Hunsinger Rezone, P-18-004

Please accept the following comments from El Paso County Public Health regarding the project referenced above:

RE-ZONE EXHIBIT

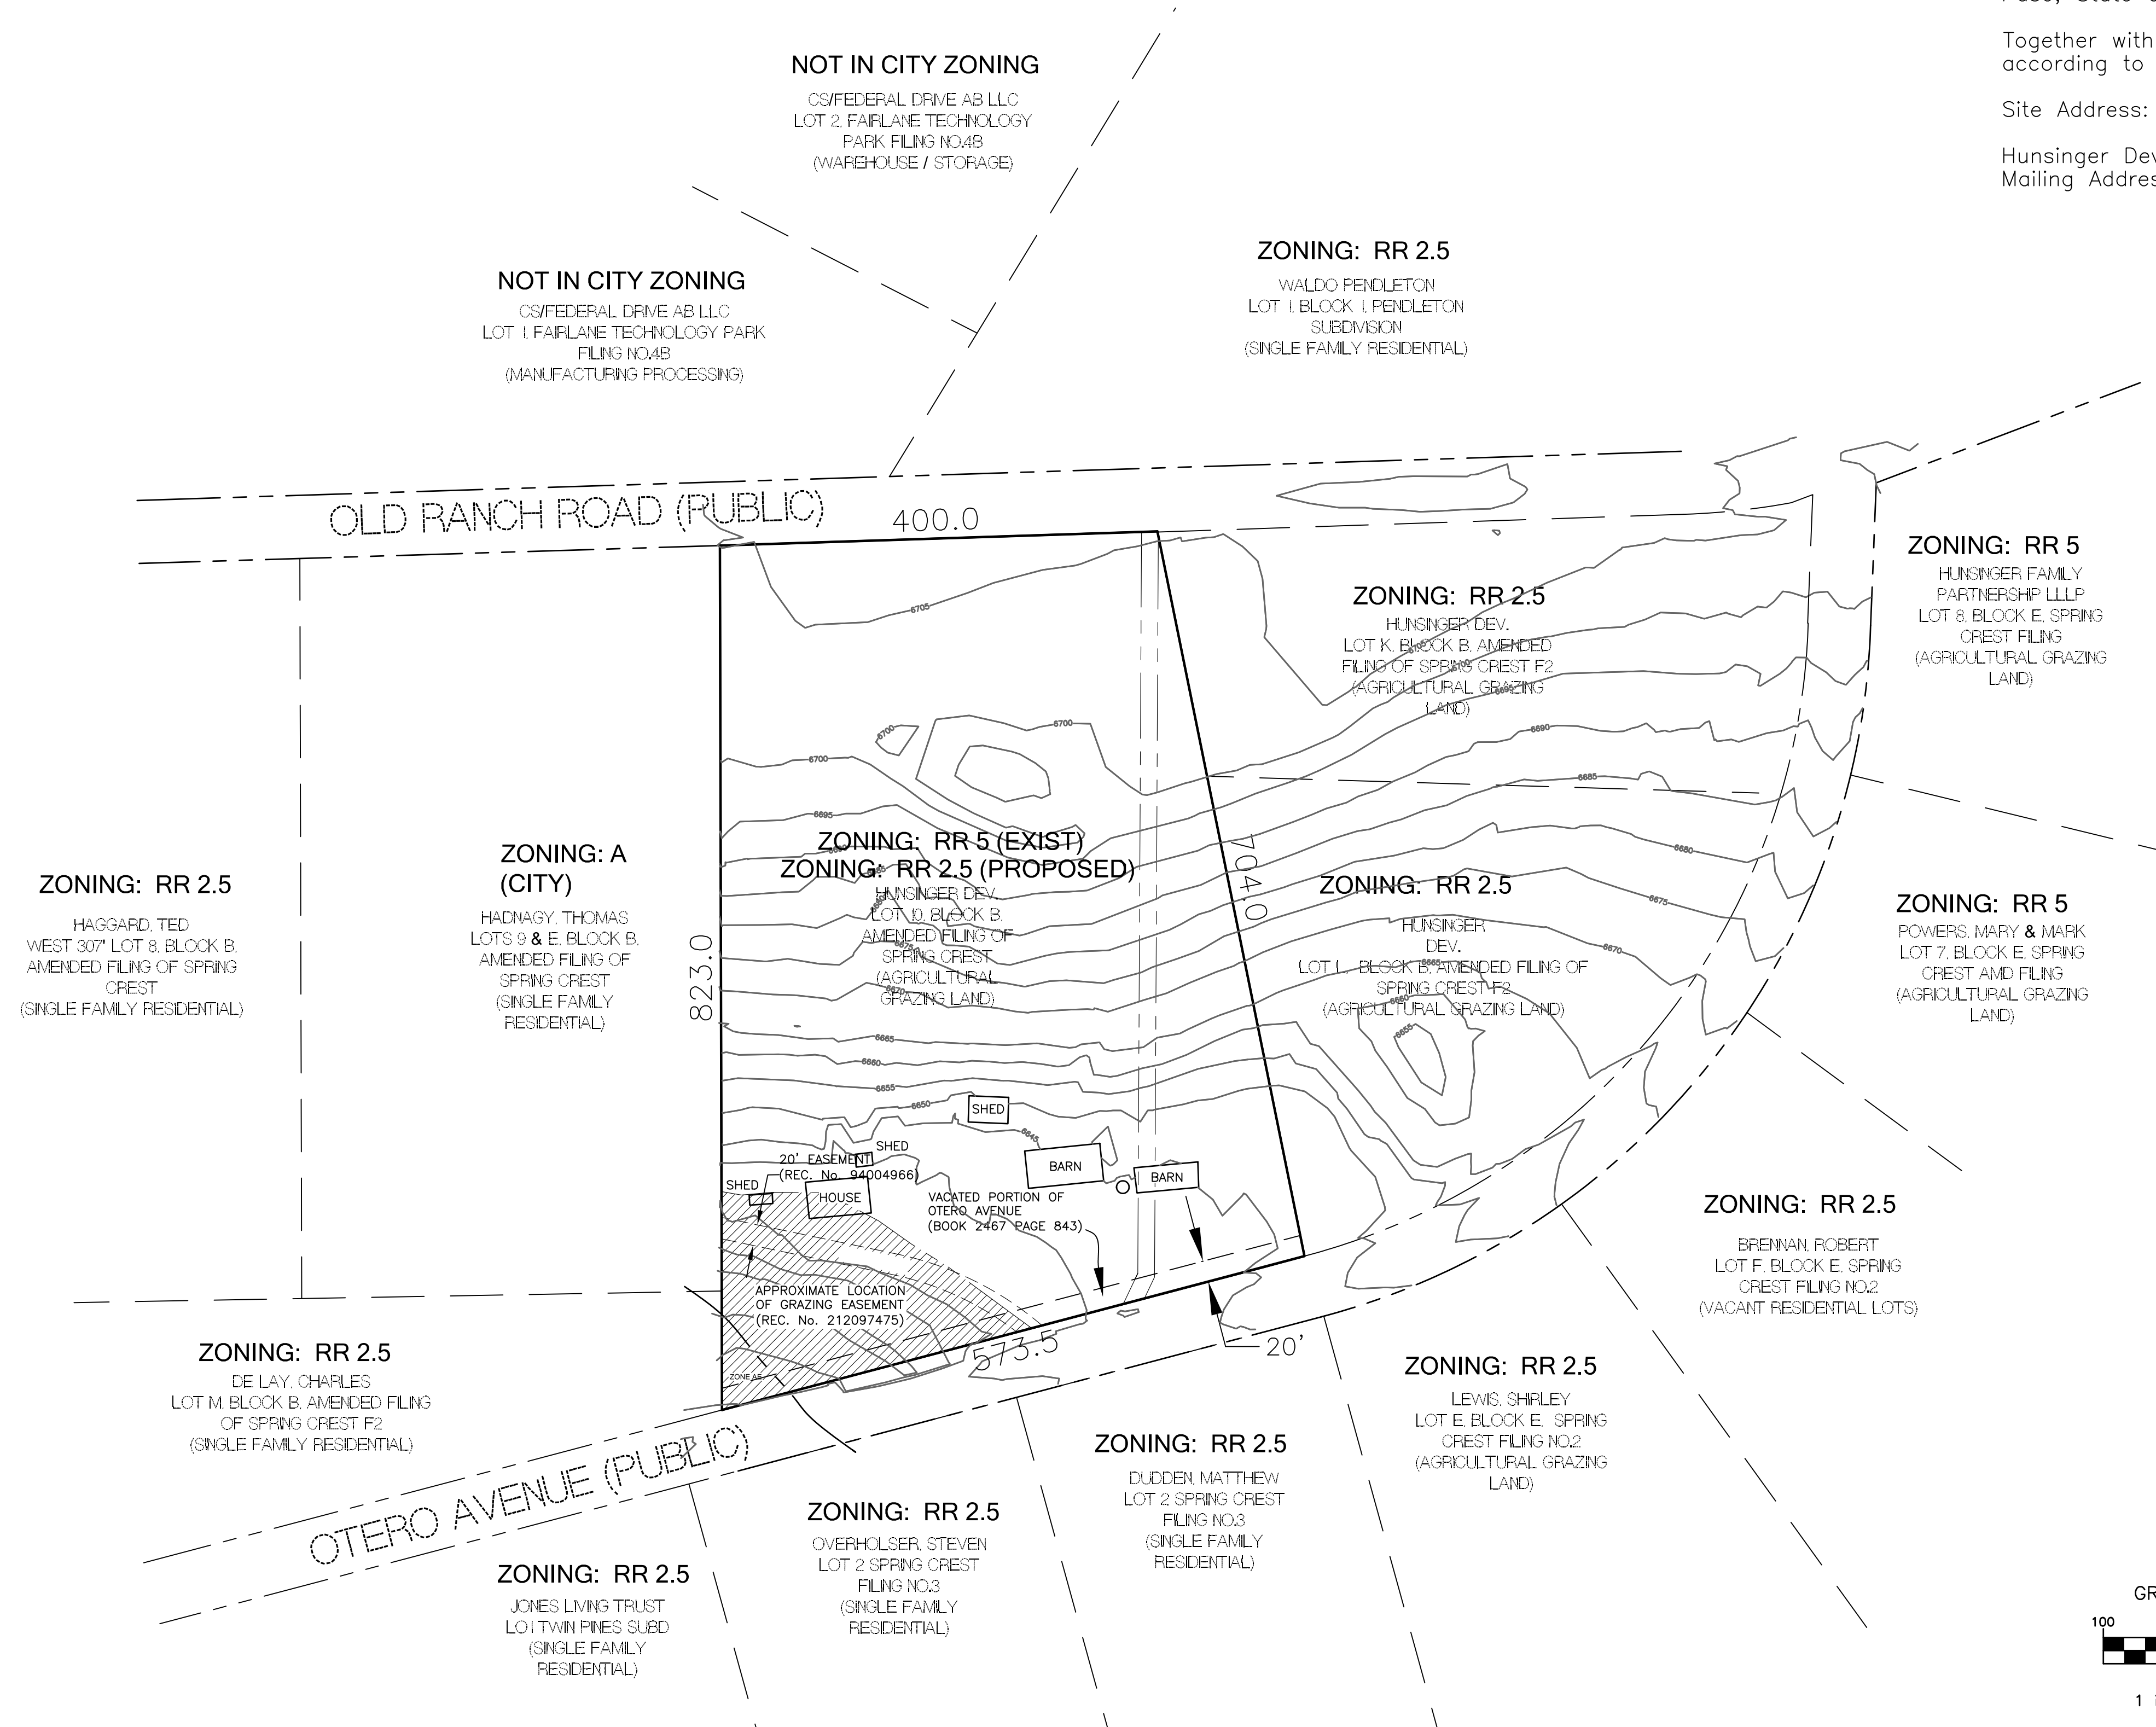
- **Future structures and the existing residence constructed the original Lot 10 must meet all Onsite Wastewater Treatment System (OWTS) Regulations. This includes the setbacks of the existing OWTS to any existing or new property line.**

- **Individual private wells must meet the minimum setback requirements from OWTS components as required by the Onsite Wastewater Treatment System (OWTS) Regulations within Chapter 8 of the El Paso County Board of Health Regulations.**
